PLANNING AMENDMENT

H08/0440/01

Alterations, new dormer windows etc

Alterations to 2 Wargate Way, Gosberton
Application No:H08/0440/01

Project Proposed Alterations 2 Wargate Way, Gosberton, Spalding, Lincs.		
Drawn: PROPOSED ELEVATIONS		
Scale	1:50	Date Oct 2000
Drawn no	01030:04	Rev.

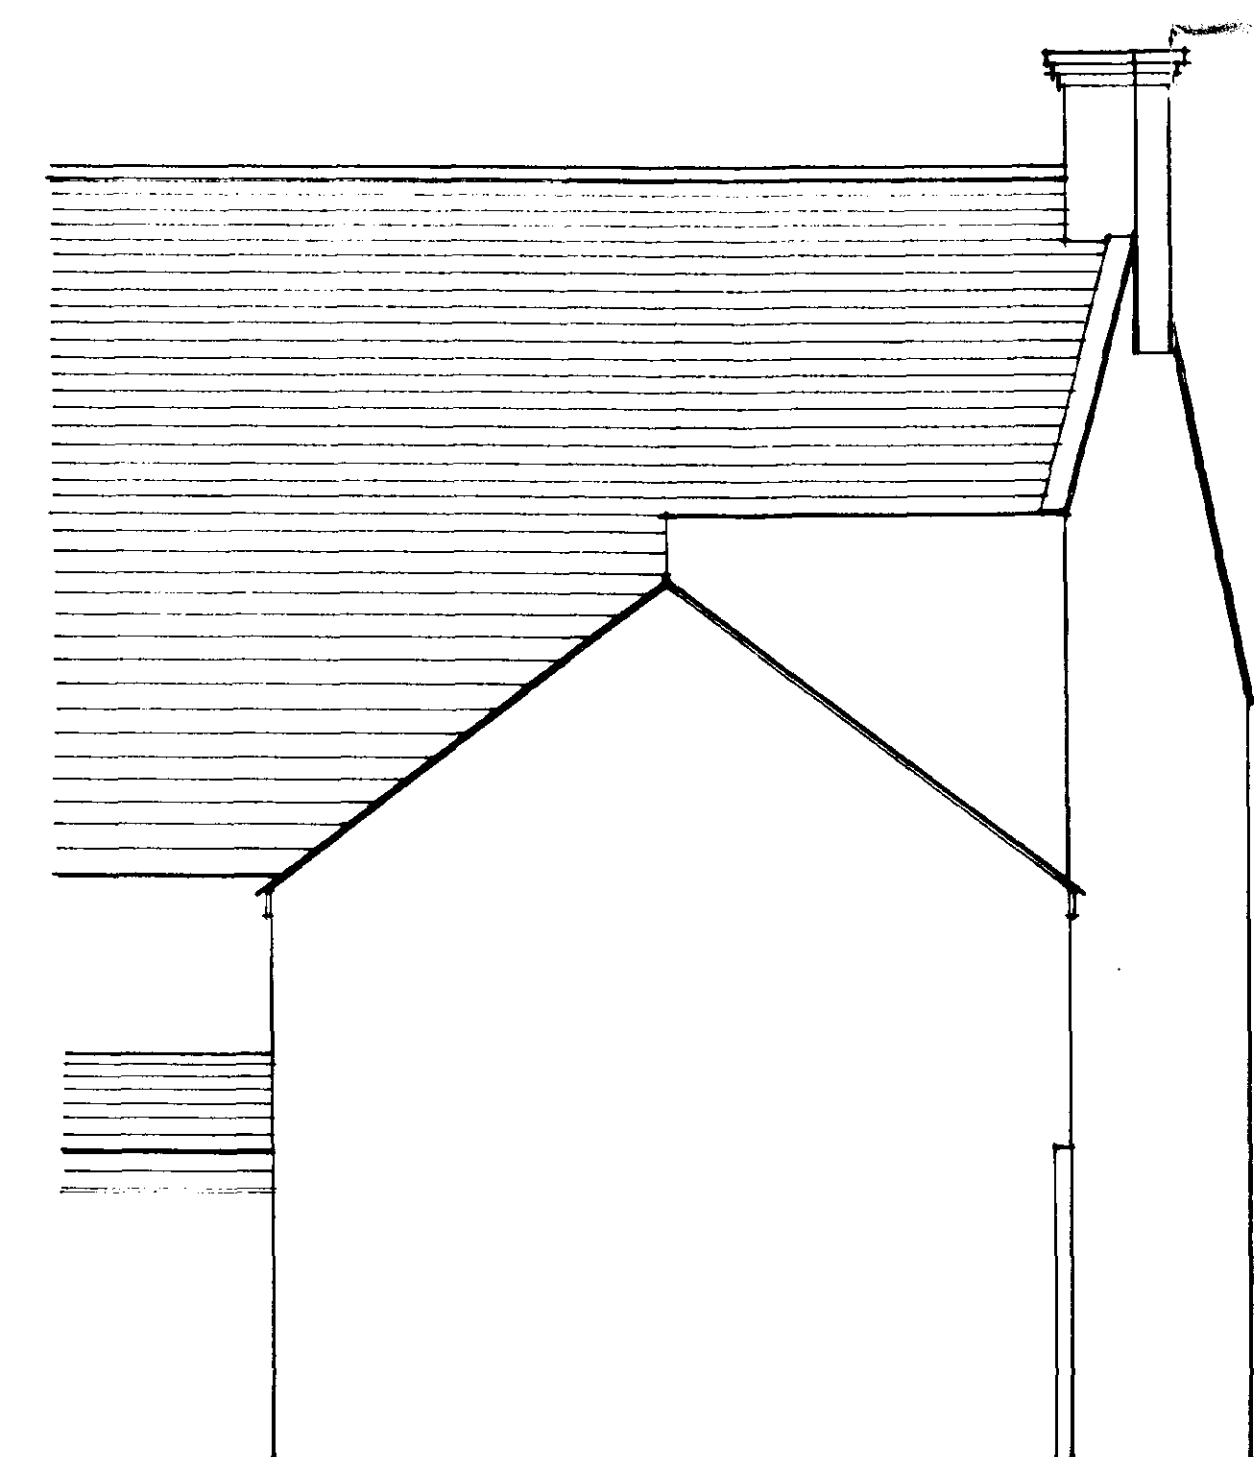
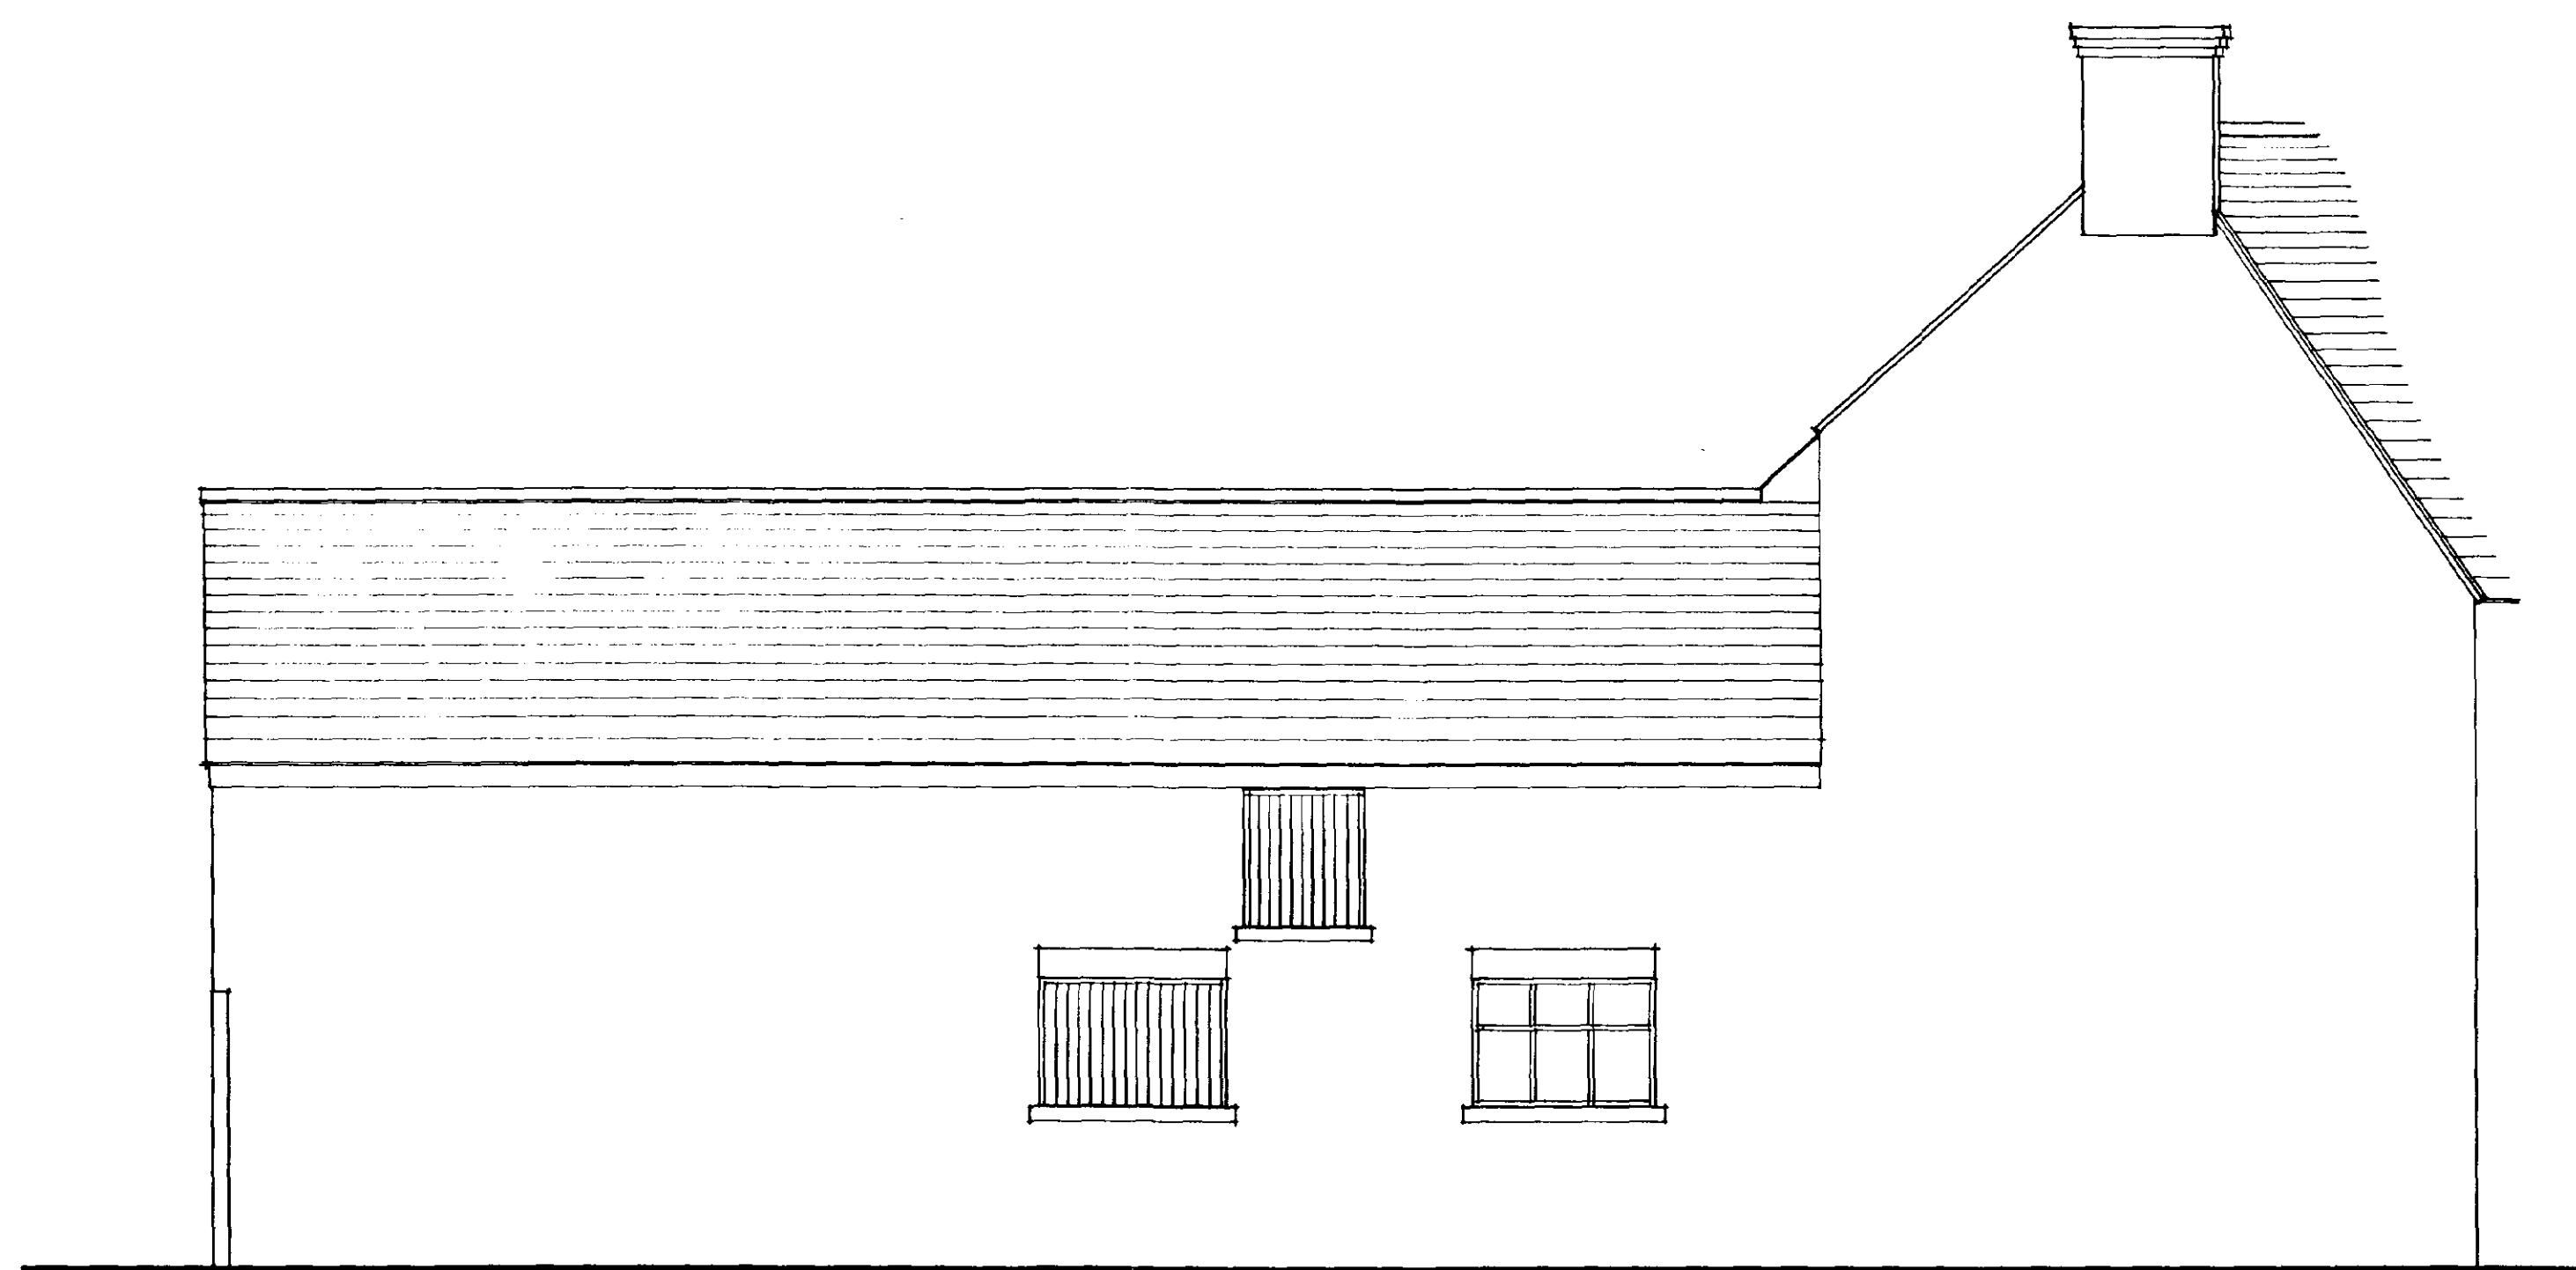
Following my discussions with Mr Roberts and Mr Scrivens I have enclosed 4 copies of dwg no 01030/04 Rev A Proposed elevations, and dwg no 01030/03 Rev A.

- a) The facades will be rendered.
- b) With rainwater gutters now continuous below the dormer windows, these will use the existing downpipes.
- c) The fascia boards of the dormer windows are the trunkated type.
- d) The ground floor windows will be internal opening casements.
- e) All timber is to be painted to match the existing original paintwork.
